Your Ref: OWPC13168
Our Ref: LU/52/17/NMA 14-02-2017
Please ask for:
Mrs A Gardner

Application for non-material amendment following a grant of planning permission LU/314/16/PL relating to re-orientation of the building to the East, amendments to internal layout at ground & first floor levels. Removal of mezzanine floor level with the plant being distributed throughout the remaining building envelope. Reduction in overall width of the building by 1m. Reduction in overall floorspace and loss of one no. toilet. Reduction in maximum building height. Reduction in width of main swimming pool. Amendments to proposed car parking arrangement & amendments to energy strategy.
Littlehampton Swimming & Sports Centre Sea Road Littlehampton

Figure 9: Proposed ground floor plan

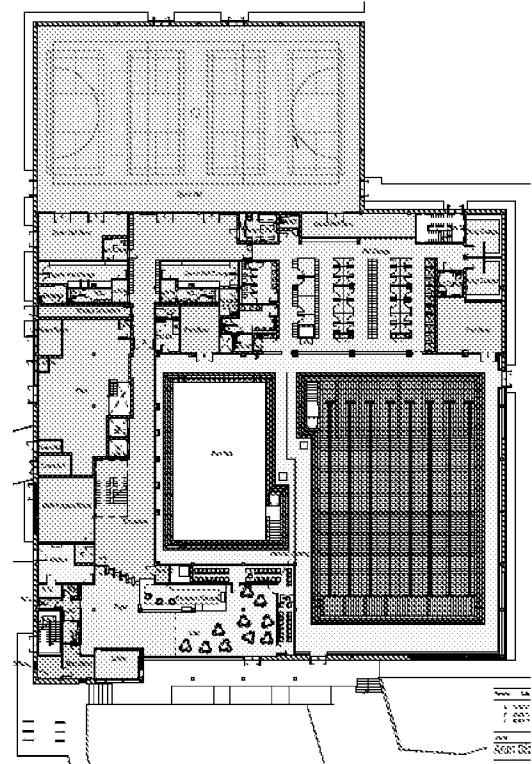
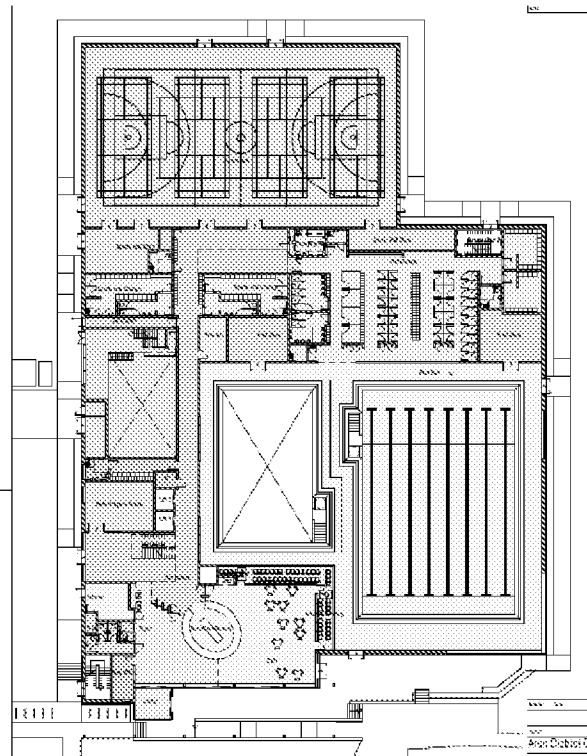
After looking at the revised drawing I note a decrease in the width of the pool by 0.5m, a huge reduction in the foyer area at the front (circa 200m²) and the omission of the photovoltaic panels.

To reduce the pool further would be a insult to these comments and reduce the maximum capacity of the pool across the its life span. Further to this, after looking at Sport England's guidance on pool sizes, by reducing the pool width from 17m to 16.5m takes the pool down a category from a county standard pool to a community pool. As seen here <https://www.sportengland.org/media/4172/swimming-pools-2013-appendix-1.pdf>
